STATE OF NORTH CAROLINA
DEPARTMENT OF TRANSPORTATION

December 20, 2019

Subject: **Modification Request for Section 404 Individual Permit, Section 401 Water Quality Certification and Neuse Riparian Buffer Authorization** for Interstate 40 Widening and Improvements from I-440/US 64 (Exit 301) to just north of SR 1525 (Cornwallis Road), including improvements to NC 42 and SR 1010 (Cleveland Road) in Wake and Johnston Counties, Federal Aid Project No. IMNHF-040-4(139)301; TIP Numbers I-5111 and I-4739, Divisions 4 & 5; Debit \$570 from WBS Element 42346.3.1.

PERMIT DRAWING SHEET 91 OF 125

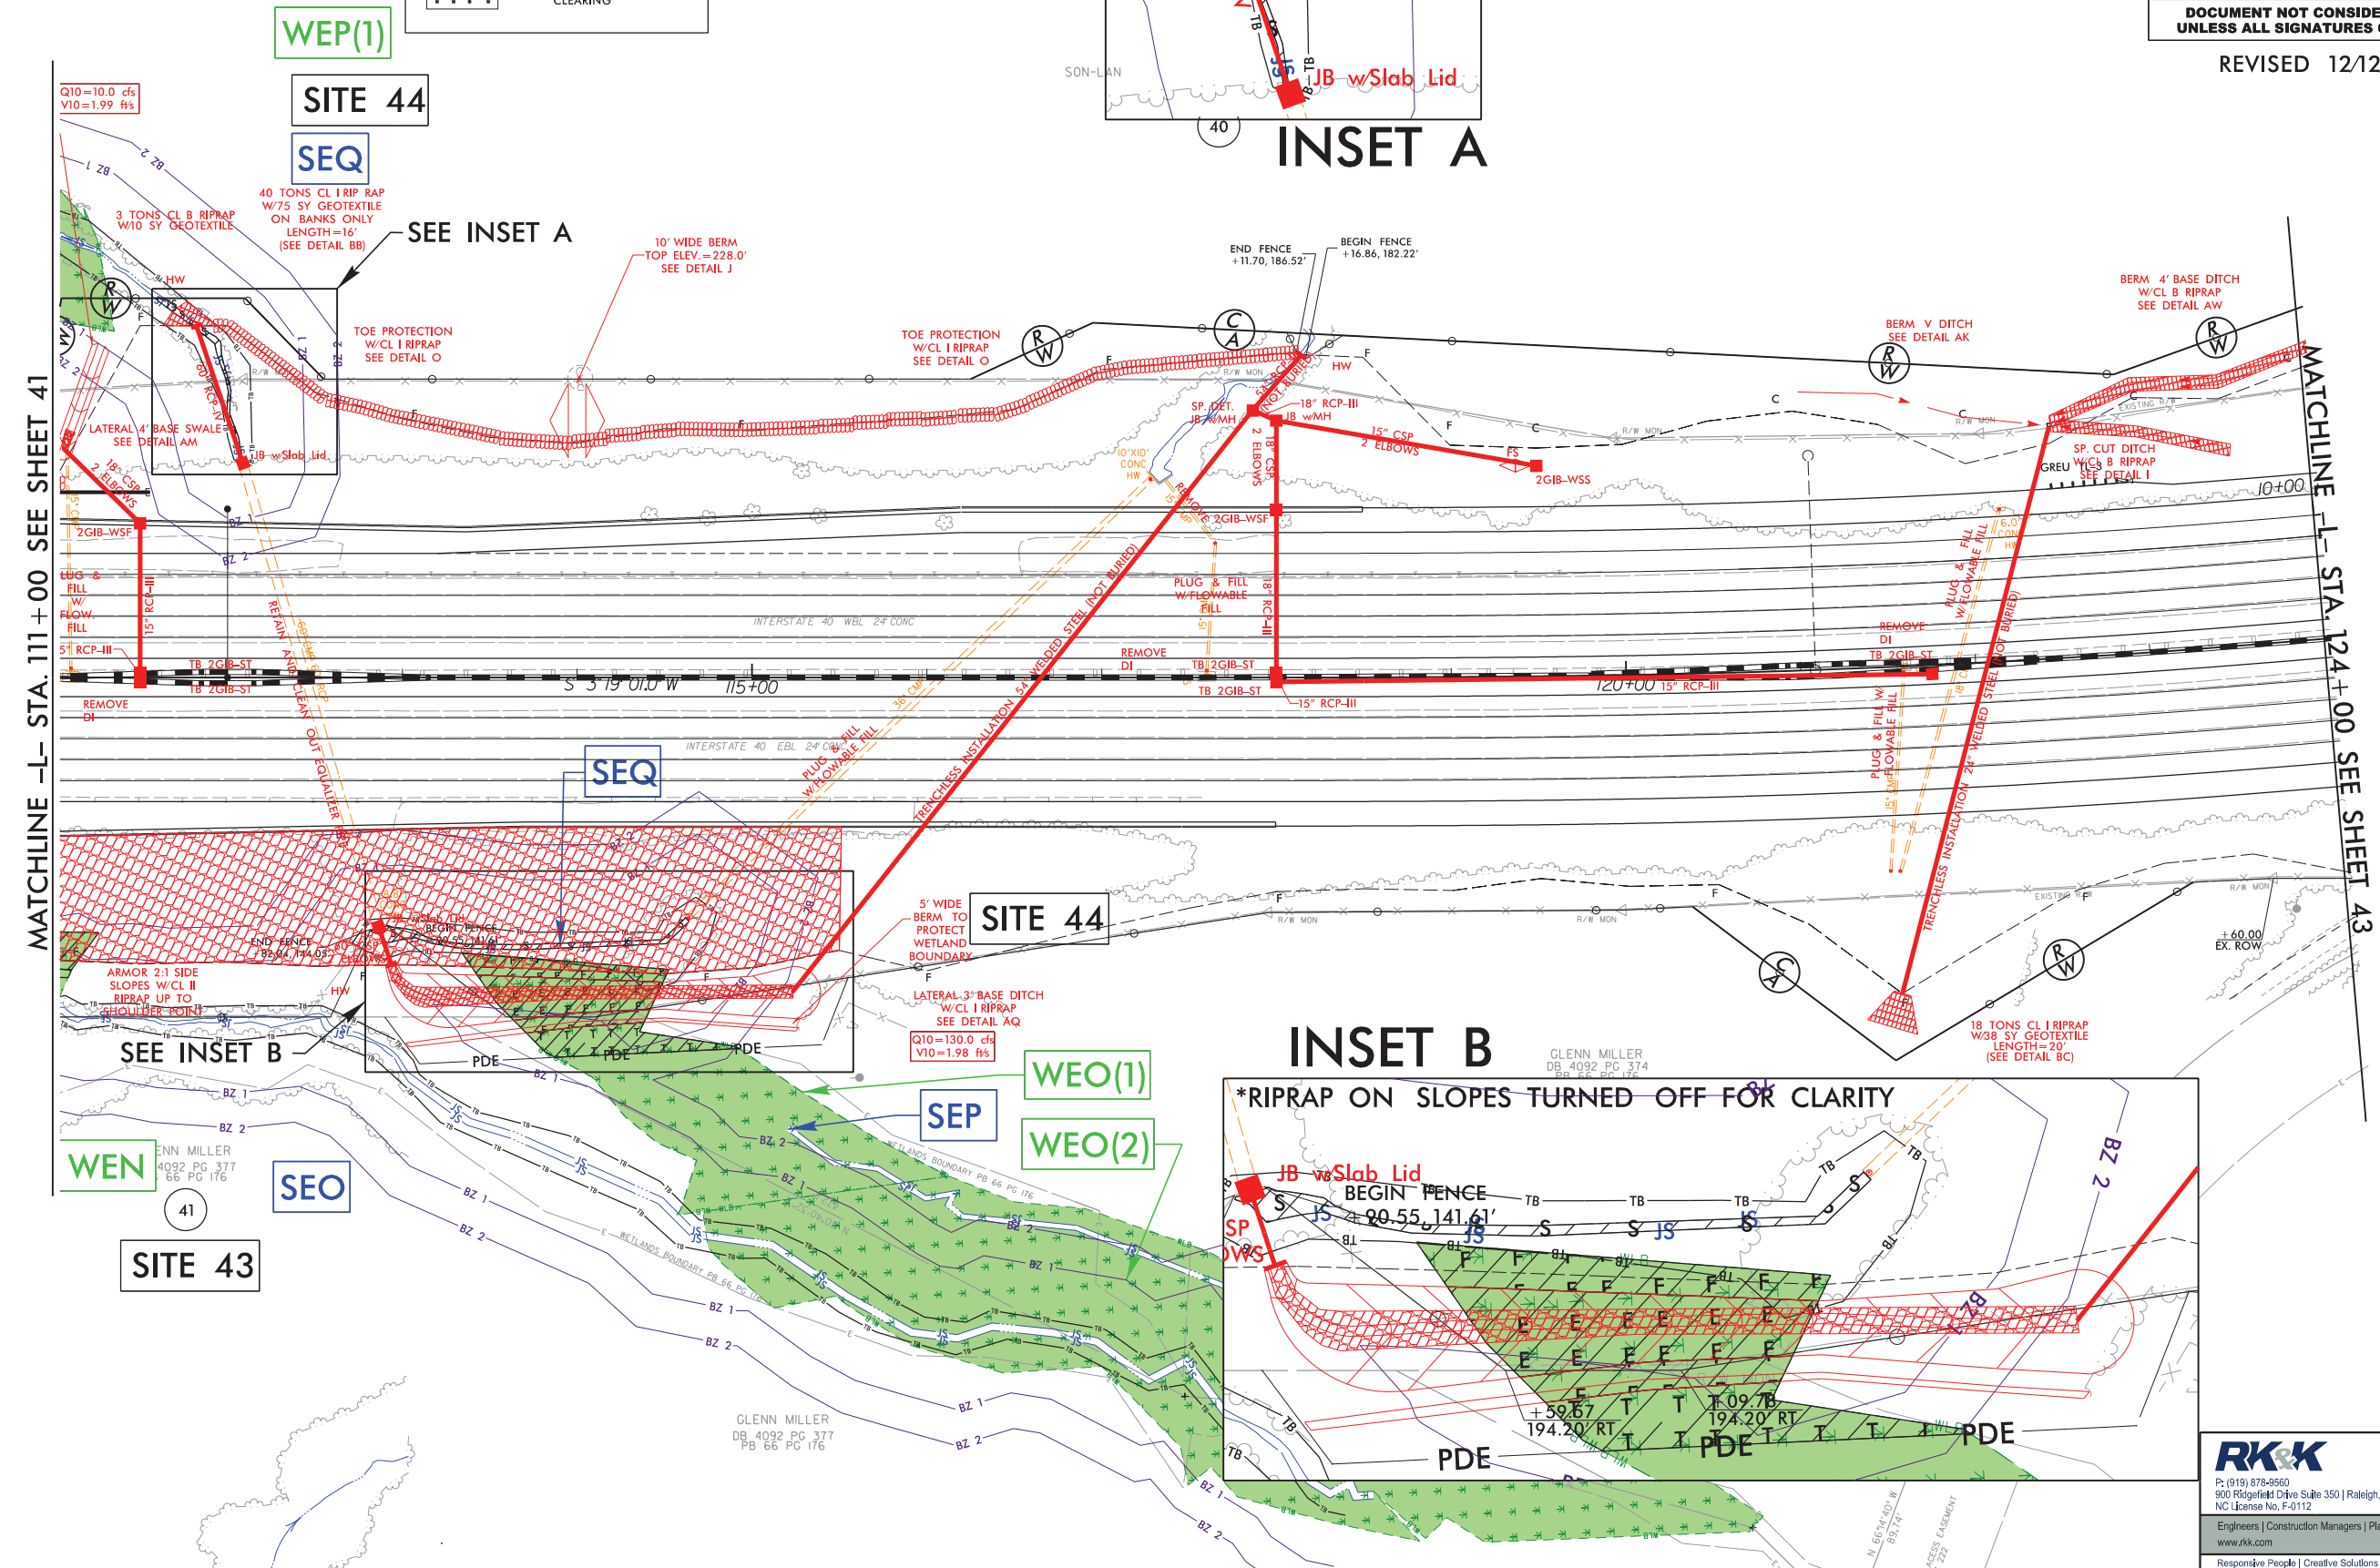
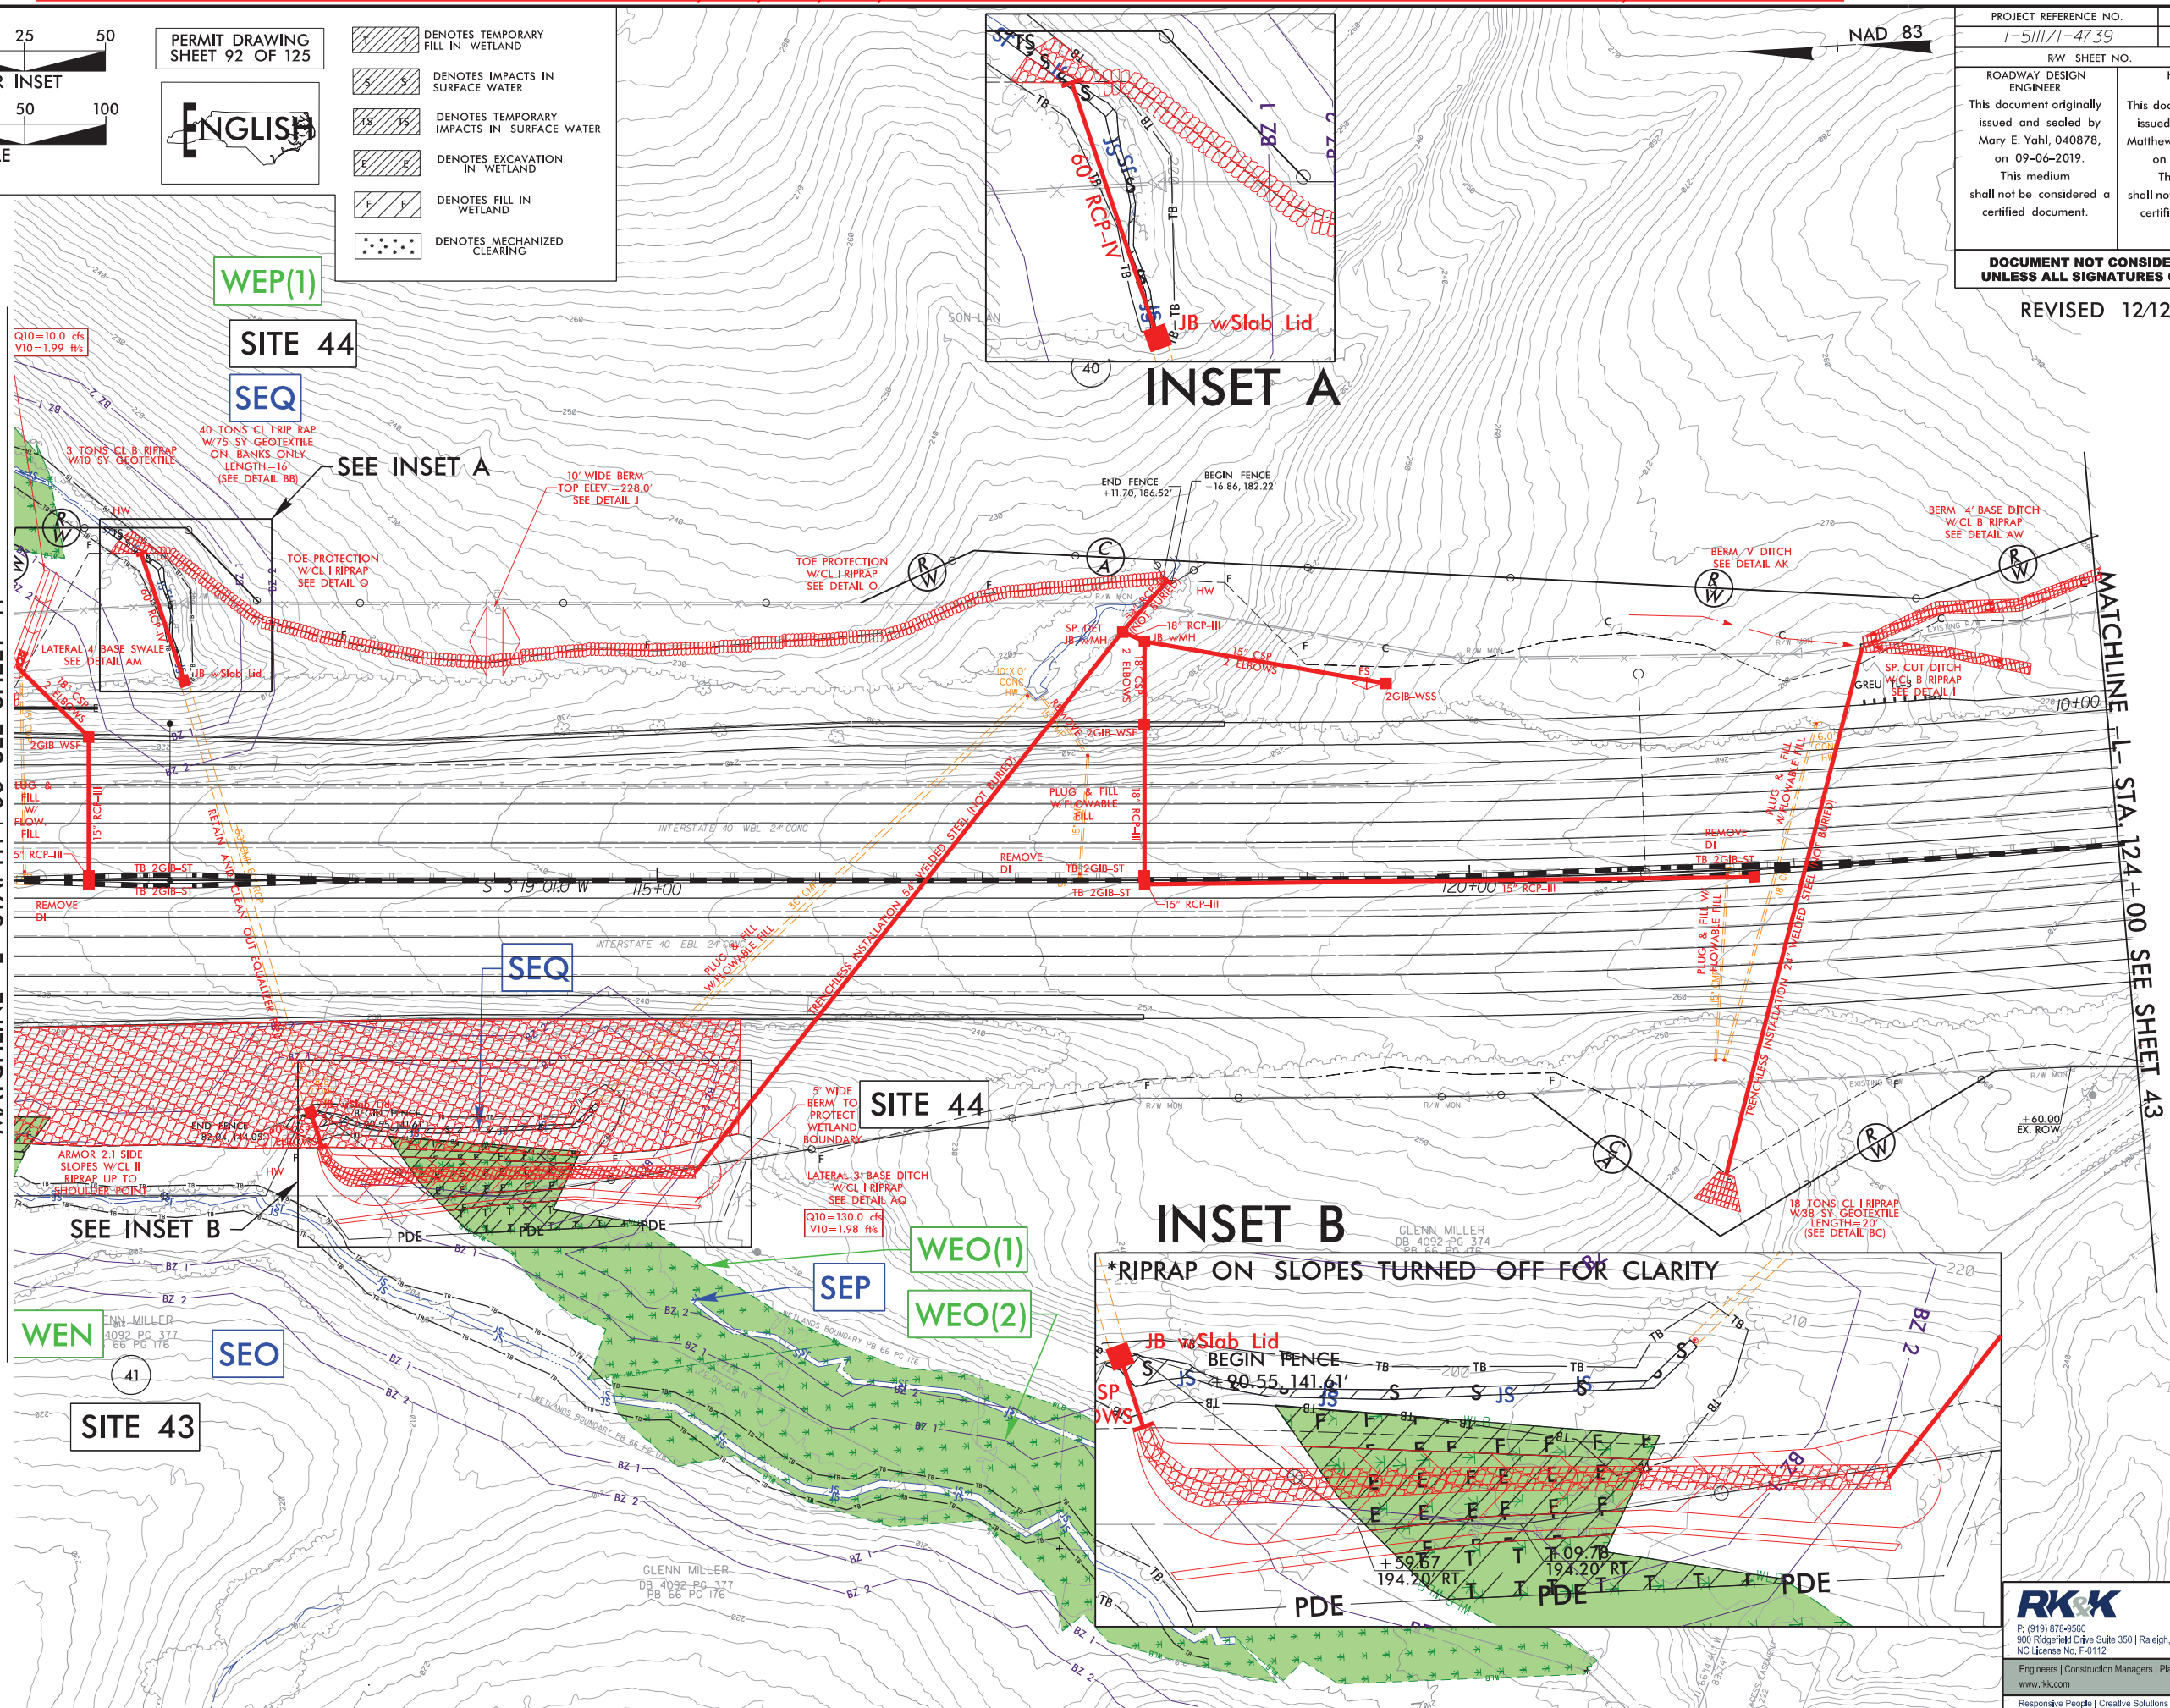
3. Site 42, -L- 106+38 – 111+14 RT will change a portion of the mechanized clearing to permanent fill in wetland. This is due to a Geotech recommendation to push riprap into the soft soils 12” – 24” deep in the area of the wetland. This limits the amount of undercutting that will need to occur. The Geotech recommendation states the station range is appr. -L- 110+00 – 125+00. The actual impacts due to the wetland shape are in the station range -L- 106+38 – 111+14. (There is a portion of temporary fill in wetland that will change to permanent fill in wetland, 0.002 ac, but it is so small that it is lost due to rounding). We do not anticipate a draining effect on the wetlands. The relocated channel will serve to function like the stream we are removing (SDN). There will be no voids in the riprap that is installed therefore we do not anticipate a discharge. Soil will be prevalent throughout the riprap.

4. There is a tributary at STA 110+00 -L- Rt which is within the foot print of the proposed Geotech recommended changes. The contractor is not proposing riprap within the stream channel; if during construction it is determined that riprap is required for long term stability, it will be installed deep below the exiting channel with enough backfill over it to retain the silt bottom of the channel. For this reason, the temporary impacts to the channel remain the same.

- Permit drawing 91 of 125: plansheet 42 reflecting revisions to Site 42
- Permit drawing 92 of 125: plansheet 42 reflecting revisions to Site 42
- Site 42: previous permanent fill in wetland: 0.23ac, previous mechanized clearing: 0.10 ac; new permanent fill in wetland: 0.29 ac, new mechanized clearing: 0.05 ac (note that rounding with all project impacts makes the total project increase in permanent fill in wetland 0.05 ac and the decrease in mechanized clearing 0.05 ac).
